16-24 Lord Street & 21-27 Roseville Avenue, Roseville

Residential development with in-fill affordable housing

I object to, and would like to provide comment upon, the State Significant Development (SSD-78996460), 16-24 Lord Street & 21-27 Roseville Avenue, Roseville (hereafter **"Proposed Development"**).

1 NORTH ELEVATION (ROSEVILLE AVENUE)
SCALE 1 : 300

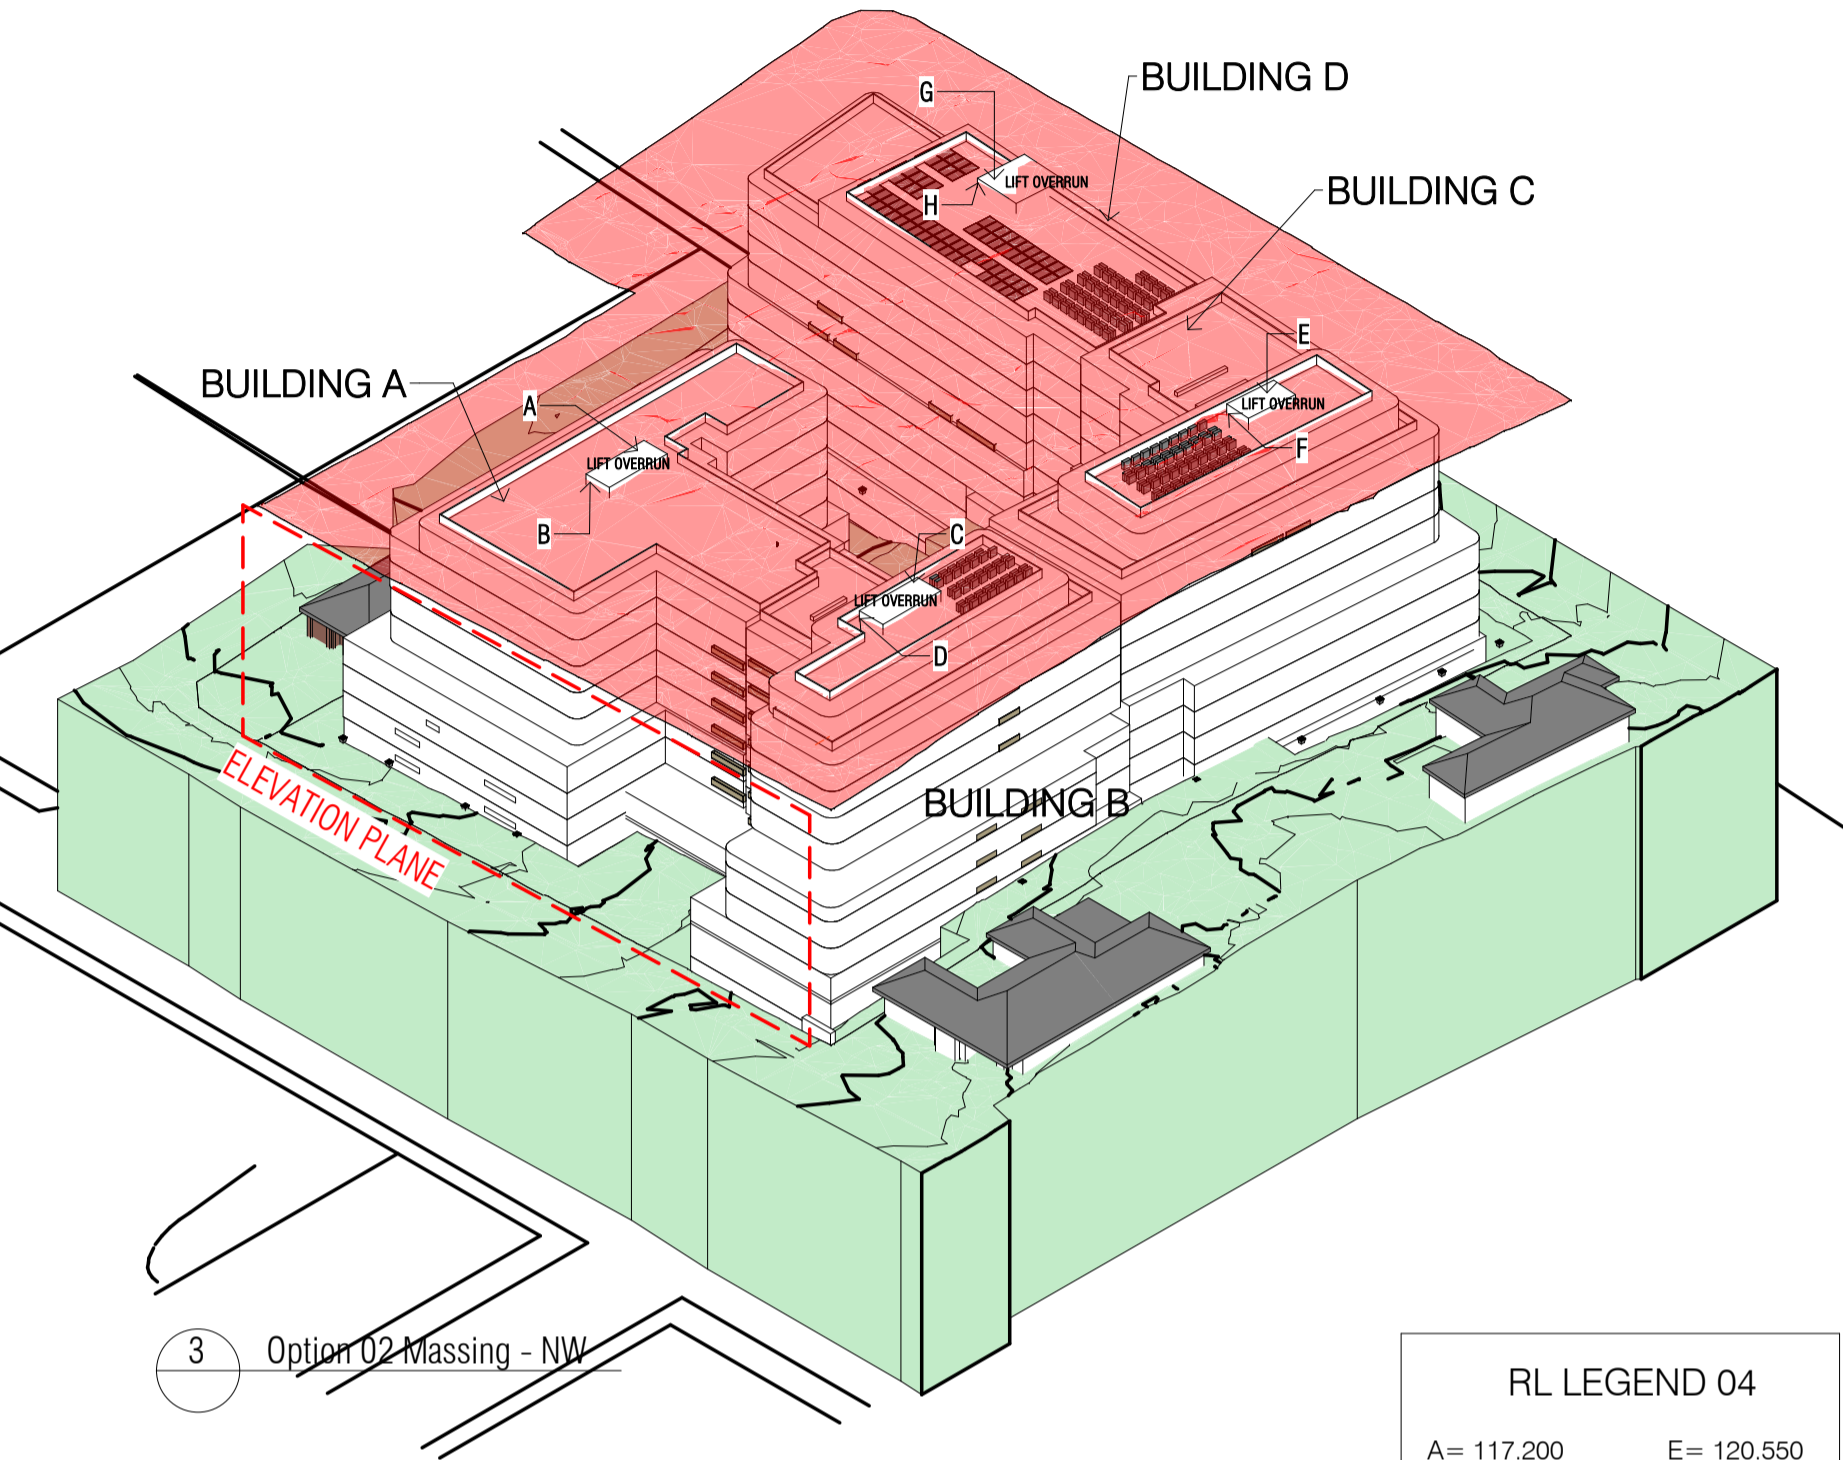
The Proposed development will have an unobstructed line of sight into Our Property at a distance estimated at less than 100 metres. An extract from the Architectural Drawings (hereafter “Northerly Drawings”) below illustrates the northern elevation of the Proposed Development looking towards Our Property. The three photos below are taken from Our Property looking towards the section of the Proposed Development illustrated in the Northerly Drawings.

The impact to me personally will be the lack of privacy into the living, bedroom and rear garden areas of our home. Occupants of the Proposed Development will be able to look directly into our family room, lounge and dining area. Our rear balcony will be completely visible from the Proposed Development and there will be a direct line of sight from the Proposed Development into our master bedroom and garden.
